## Response of the environmental NGOs to Horizon's Deadline 9 Tern Compensation Package [REP9-028]

Wylfa Newydd Development Consent Order EN10007

Interested Parties North Wales Wildlife Trust (20011639)

The Royal Society for the Protection of Birds (20011586)

Figure 13-2 Glan y Môr and Morfa Madryn

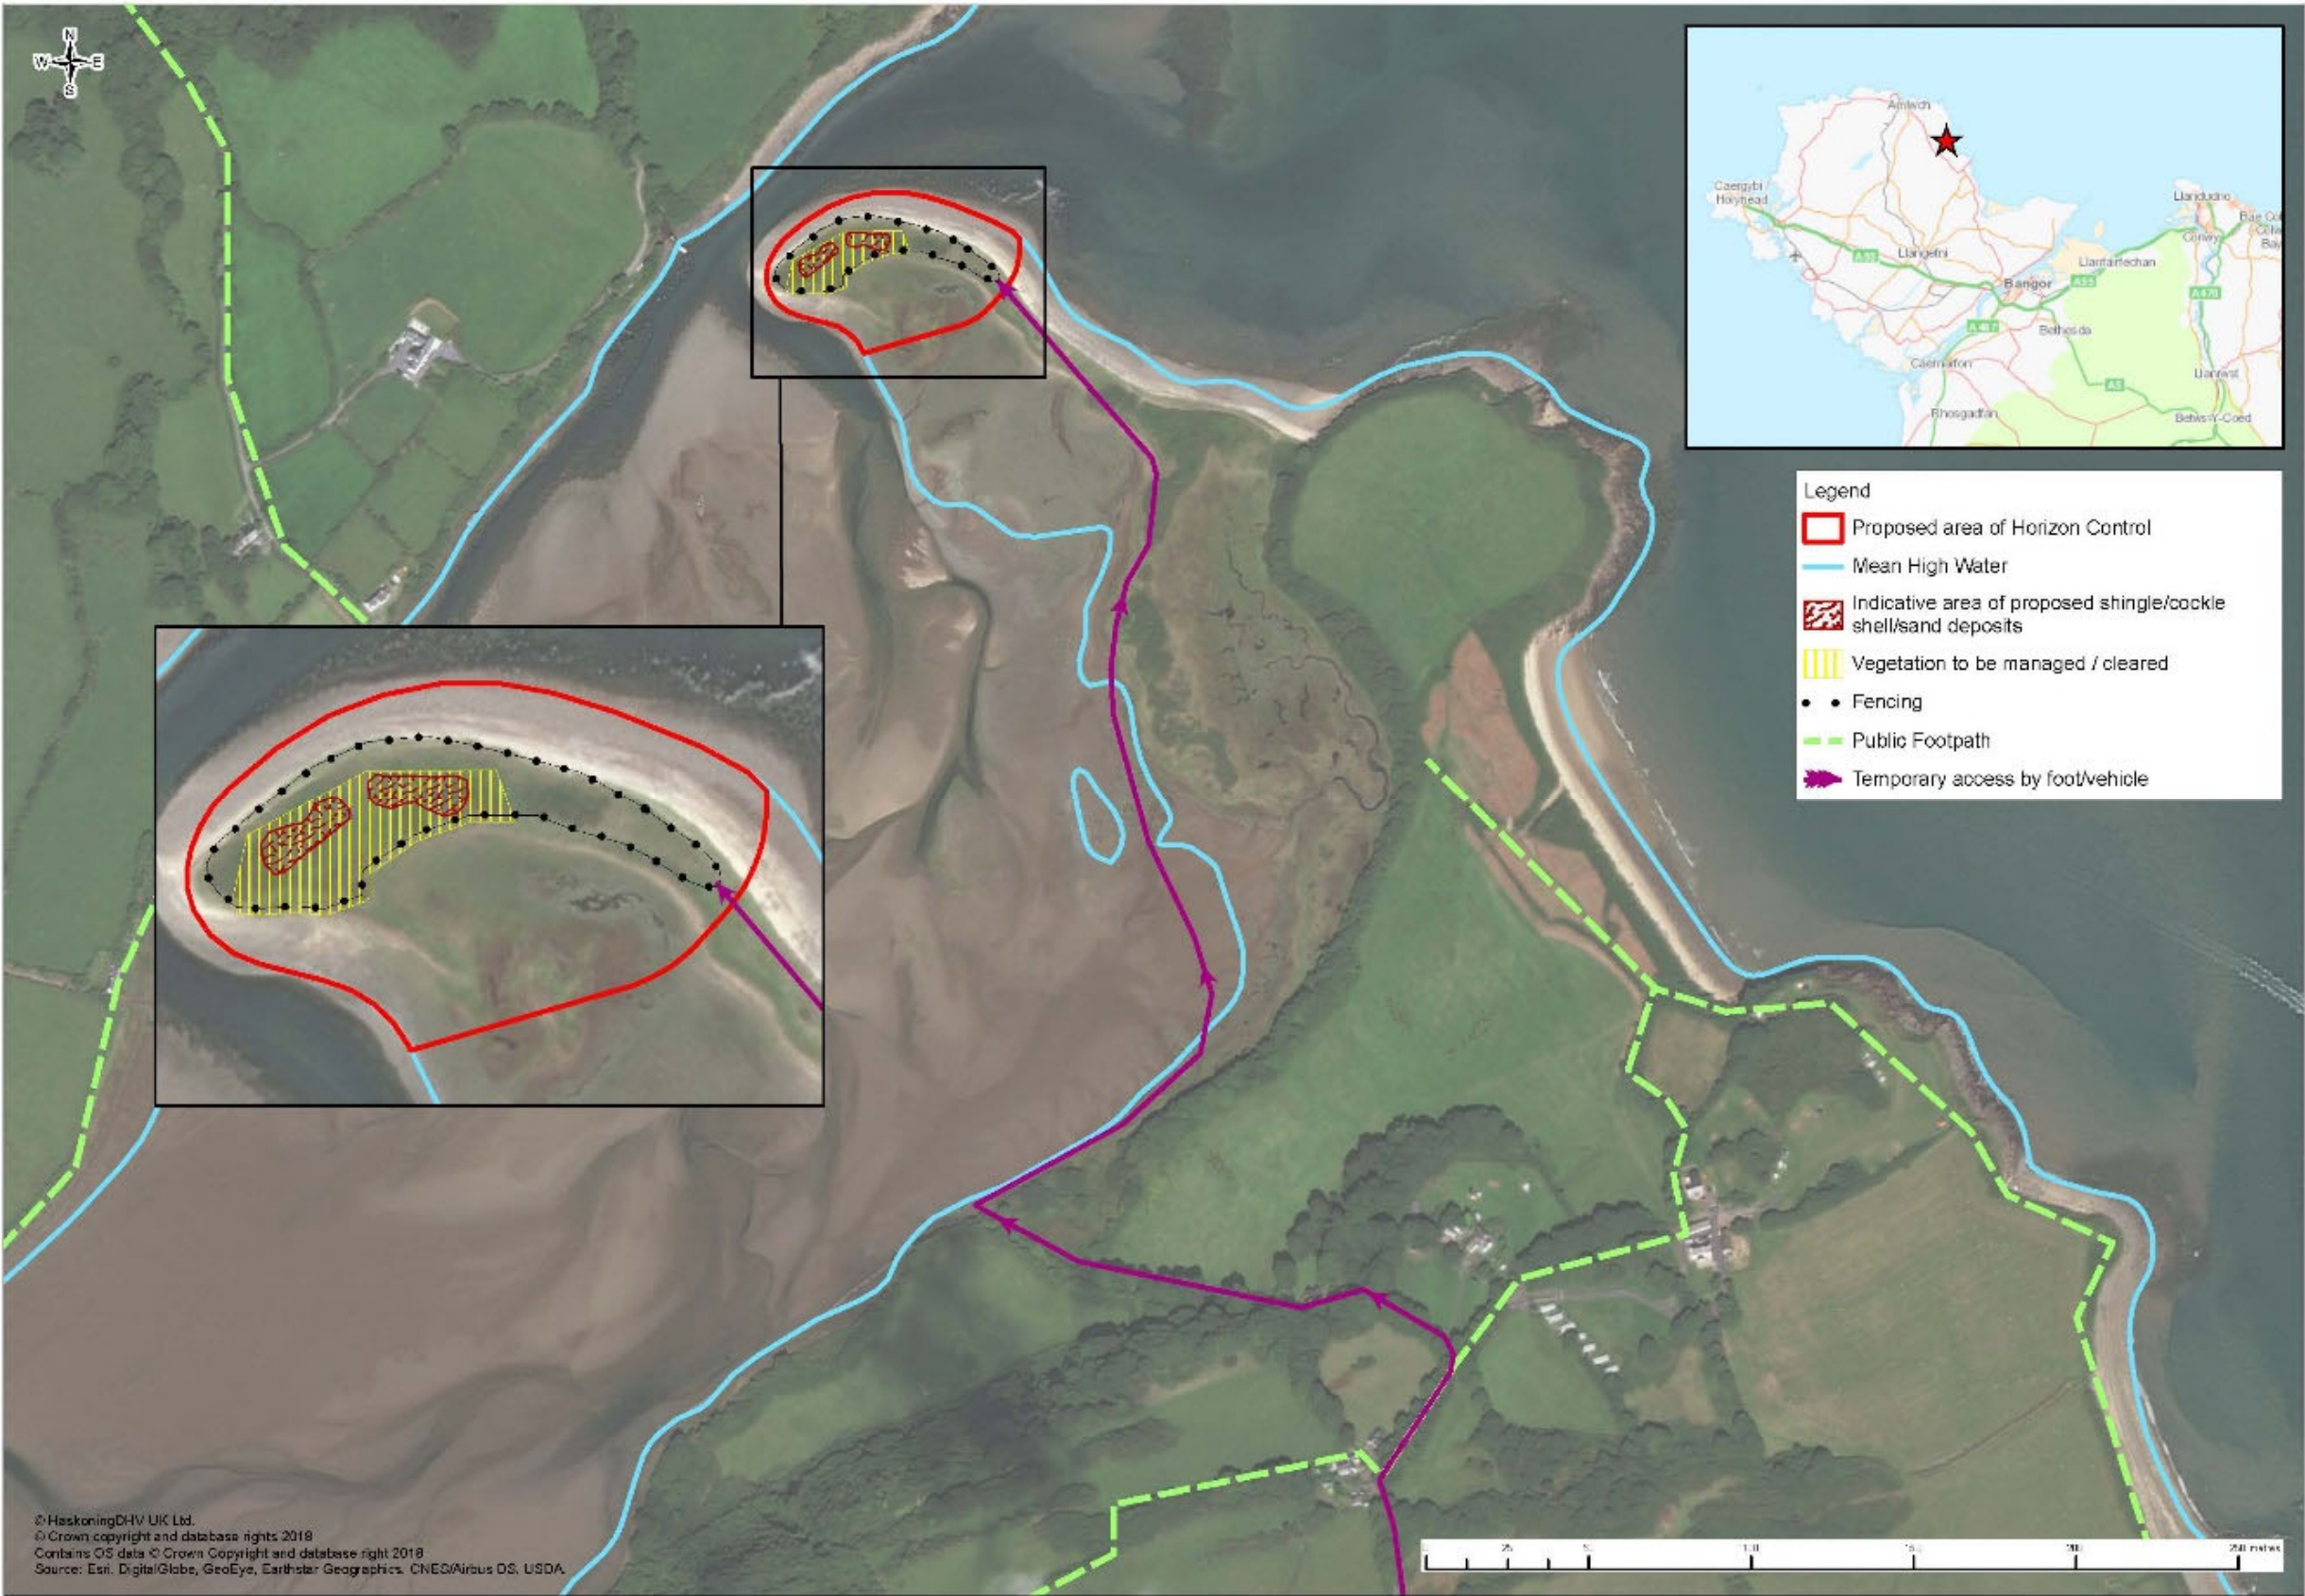
1.12 It is of note that WN[x] "Tern Compensation Sites"<sup>6</sup>, as currently defined, separates Glan Mor Elias and Morfa Madryn, which could additionally allow the Applicant to claim that they have discharged their responsibility for two sites by preparing just this one co-joined site.

As indicated elsewhere in Horizon's Deadline 9 document, these should be considered as a single site [REP9-028  $\diamond$  1.3.5]. The eNGOs therefore suggest that this potential loophole is closed and that Glan y Mor and Morfa Madryn are listed as one site within the Requirement and at paragraph 2.3.1 for the sub-CoCP insertions.
